Application Reference: 2025/0636

Site Address: 24 Chapel Close, Shafton, Barnsley, S72 8QJ

Introduction: This application seeks full planning permission for the erection of a first floor extension above the existing porch, two storey extension to the rear and single storey extensions to either side following the demolition of the existing detached garage and rear conservatory.

Drawing Title **PROPOSED PLANS**

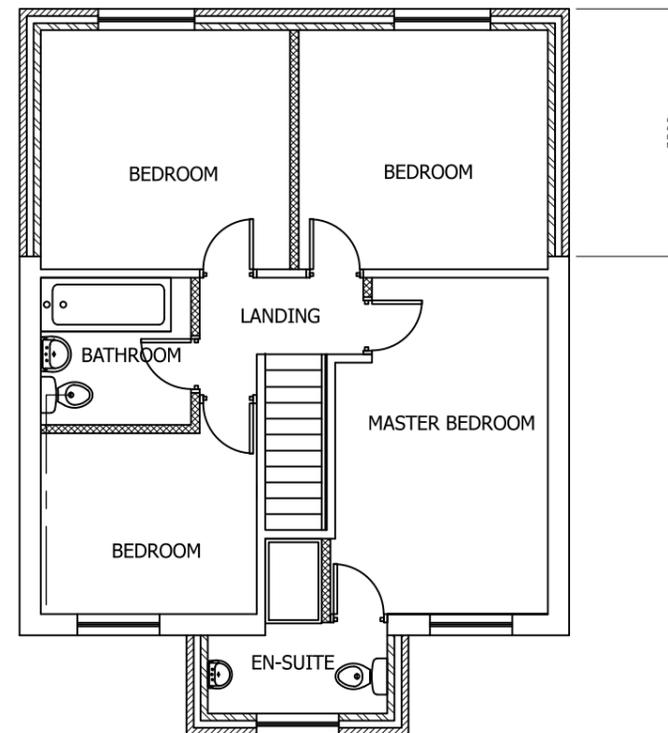
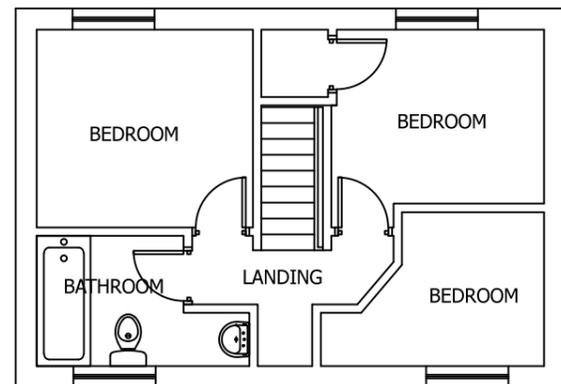
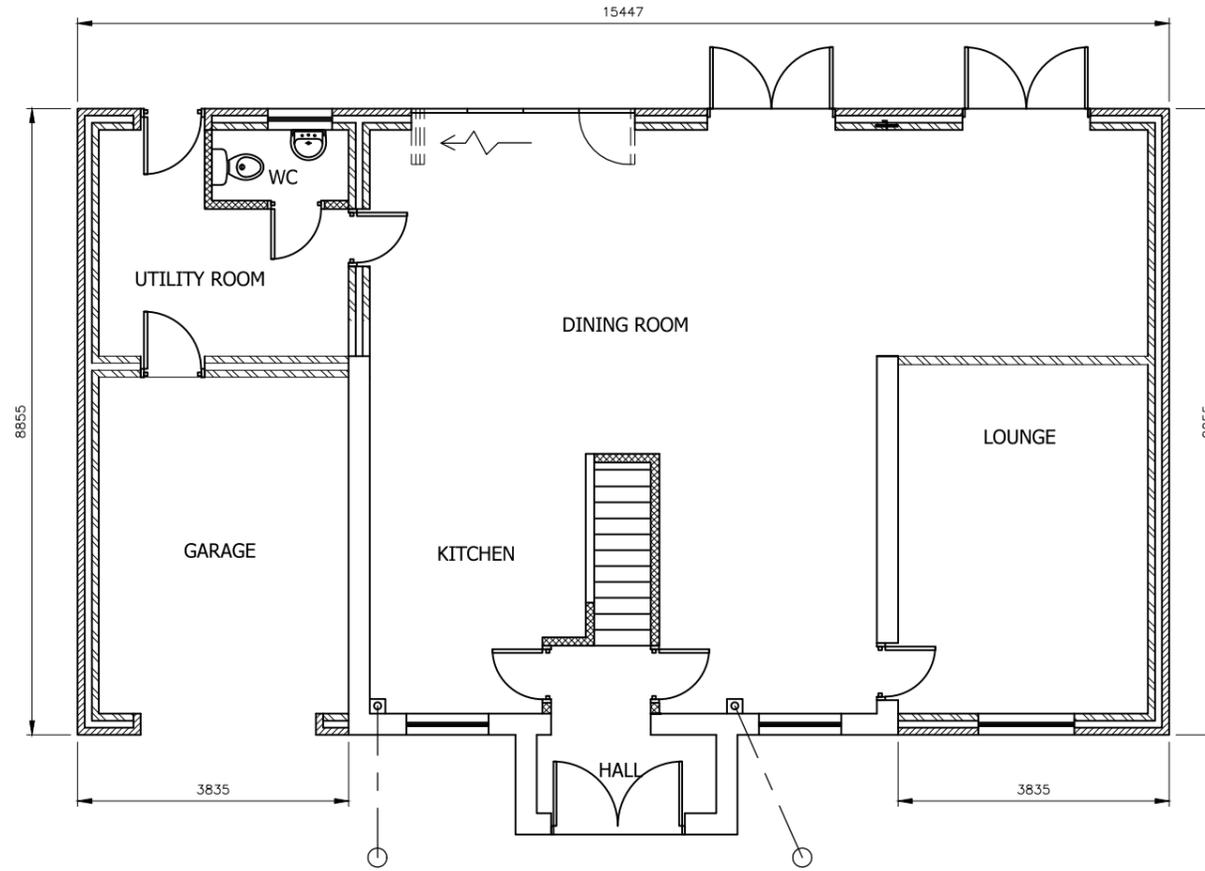
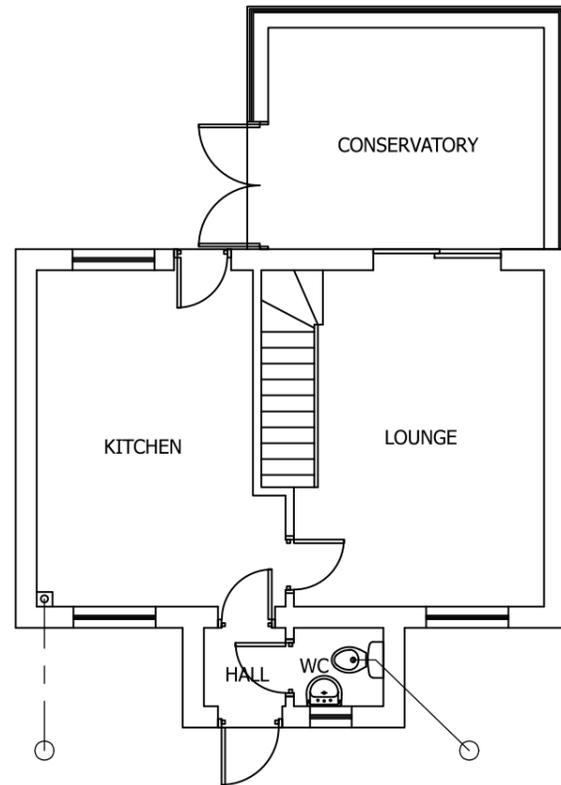
The SPD guidance for House Extensions and other Domestic Extensions states that side extensions should not exceed two thirds of the width of the original dwelling. There is no limitation on the number of or combined width of multiple side extensions, each side aspect of the proposed extension would be acceptable, as each features a side projection of 3.84m, which is just less than fifty percent of the original 7.77m width of the original dwelling.

The scale of the proposed front extension would be very modest, with an approximate 3.14 sqm ensuite bathroom being created above the existing entrance way which projects out from the main aspect of the principal elevation by approximately 1.6m.

The design of the proposal limits the two-storey aspect to the width of the original dwelling and it projects out only 3.5m, this is in line with the guidance set out in the SPD. As such, the neighbouring dwellings to either side of the dwelling should not be significantly impacted, and as noted above, the closest dwellings to the rear are over 40m away, at the other side of a paddock.

Unusually whilst the dwelling would have originally maintained two parking spaces, despite the proposed garage being of an insufficient size to be considered as an official parking space, a Highways DC consultation confirmed a query that the parking provision impacted on access to neighbouring dwellings. This initially resulted in a highways objection to the proposal, but upon

review of revised plans which indicated alternative in curtilage parking provision, subject to planning conditions, the Highways objection was withdrawn,

- In accordance with a request from Highways, an amended plan was provided to provide two in-curtilage parking spaces which did not hinder access to nearby residents.
- There was an error on the originally submitted elevations, once highlighted this was quickly corrected with revised elevations submitted.

The proposal now offers adequate on-site parking provision without obstructing access for neighbouring dwellings. As such there would be no impact on highway safety and the proposal is in accordance with policy T4 of the Local Plan.

Drawing Title **PROPOSED ELEVATIONS**

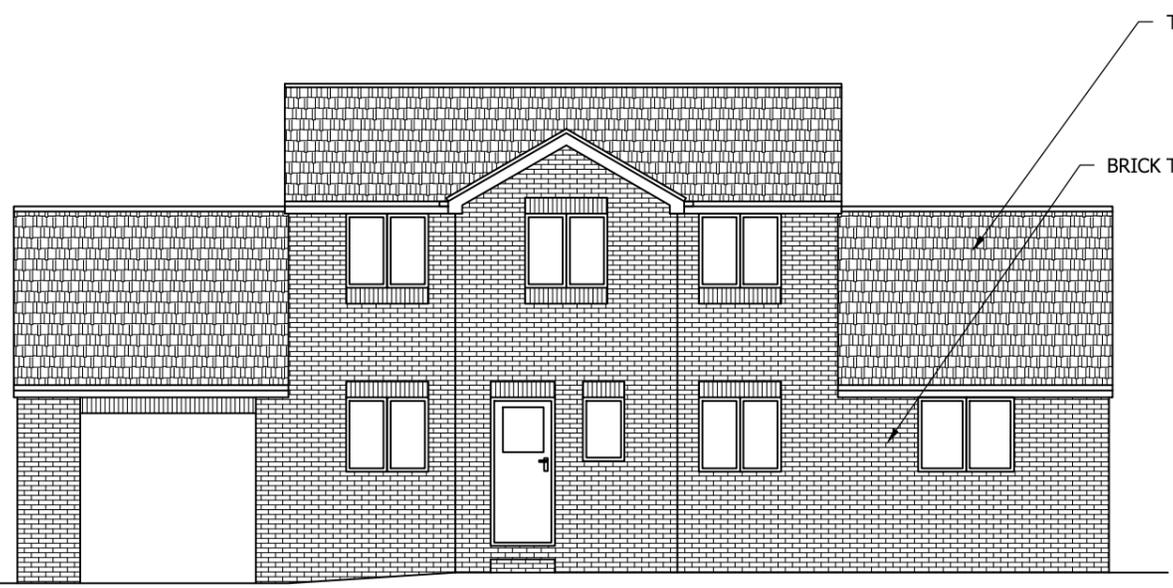
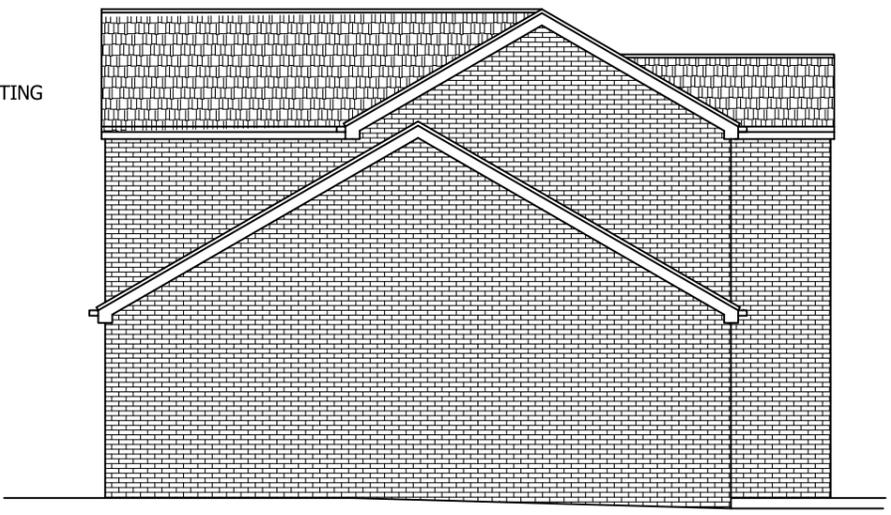
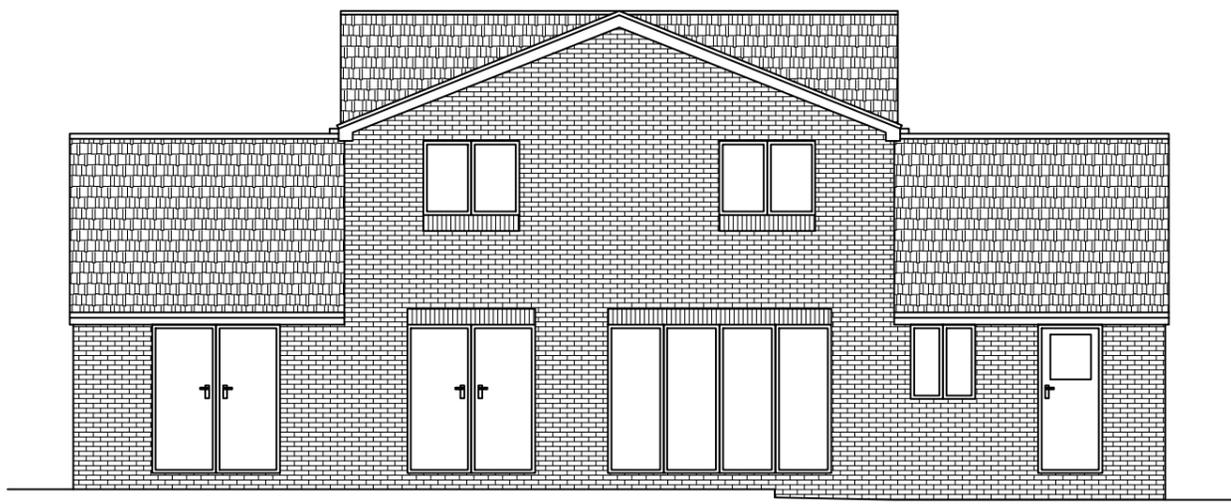
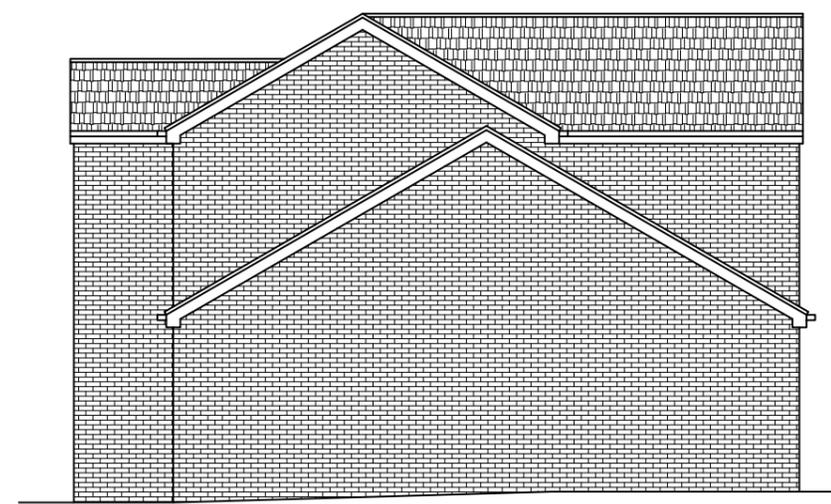
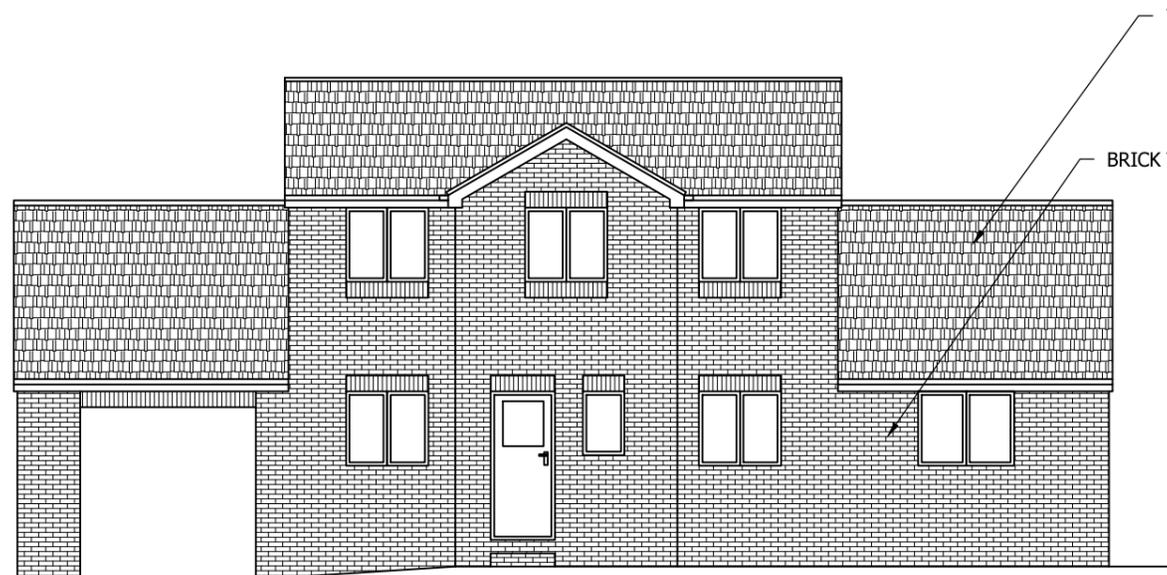
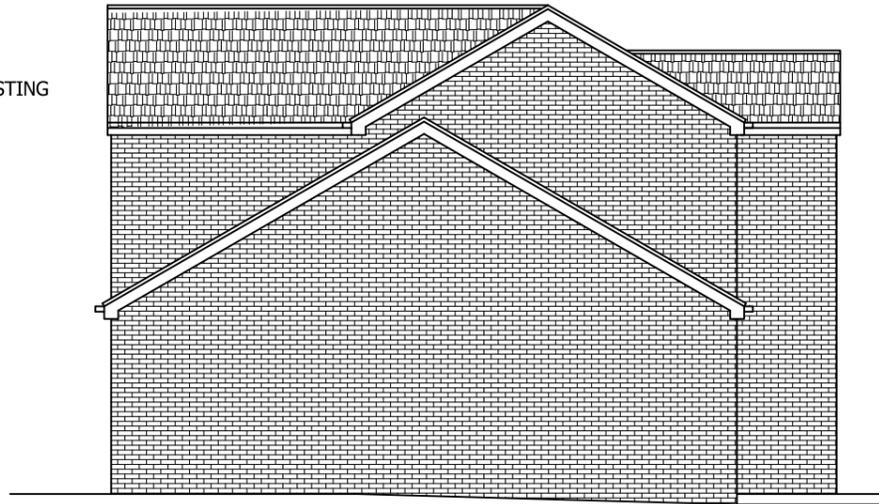
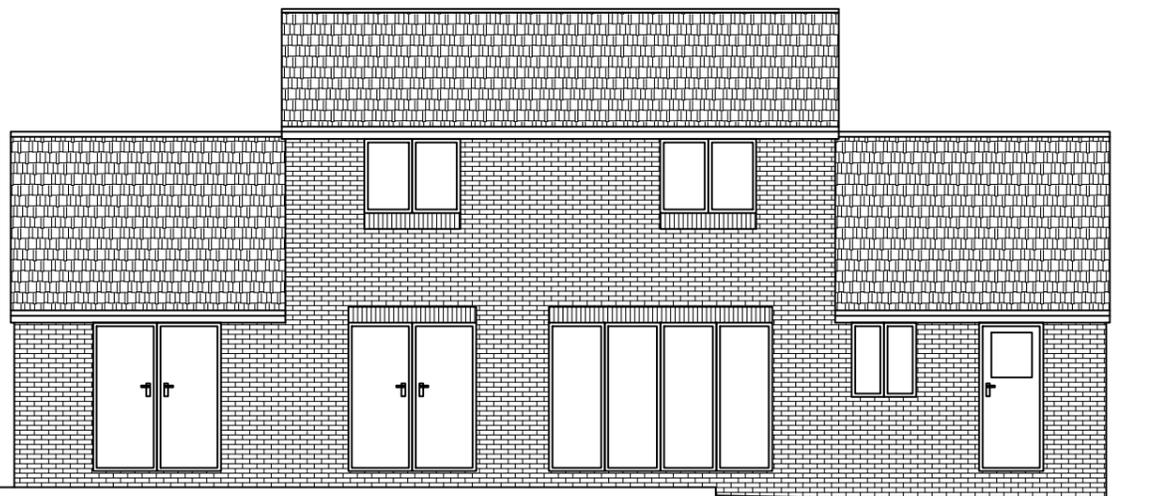
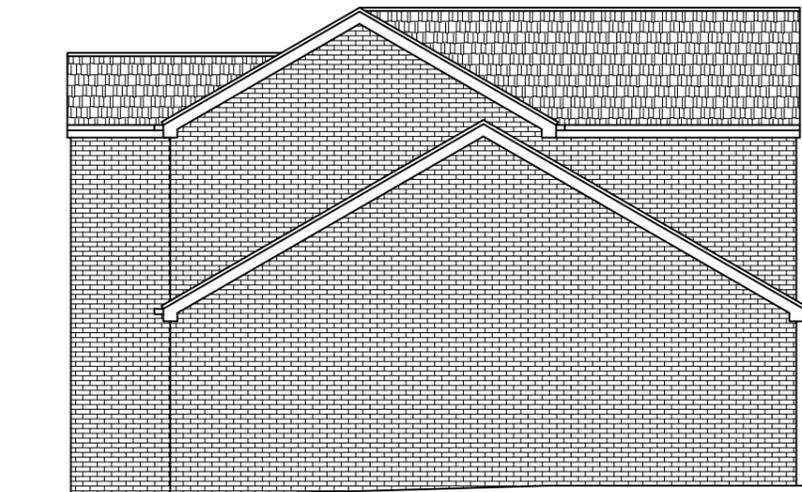
Whilst very large, the proposed wrap around extension would only have a moderate impact upon the design and character of the dwelling. With the two side extensions being of equal size

and ground floor only, although featuring dual pitched roof heights of up to 5.33, due to ground level differences; as the roof heights match the dwelling's original eaves height, they provide balance to, and demonstrate subordination to the host dwelling. As mentioned above, with the front extension being very modest in size, it would have a limited impact on the overall design and character of the dwelling.

With no side windows proposed, the potential impact on the two neighbours approximately 6.9m to the right (north) of the proposed extension, and one neighbour approximately 8.5m to the left (south) of the proposed extension, would just be the approximate 5.18m and 5.33m maximum height, respectively, of the ground floor extensions. The height difference due to land levels. The height of the extensions is larger than the 4m maximum height allowable for an extension constructed through permitted development but much less than a two-storey extension side extension which may have been proposed, and which would have been like other extensions within the estate.
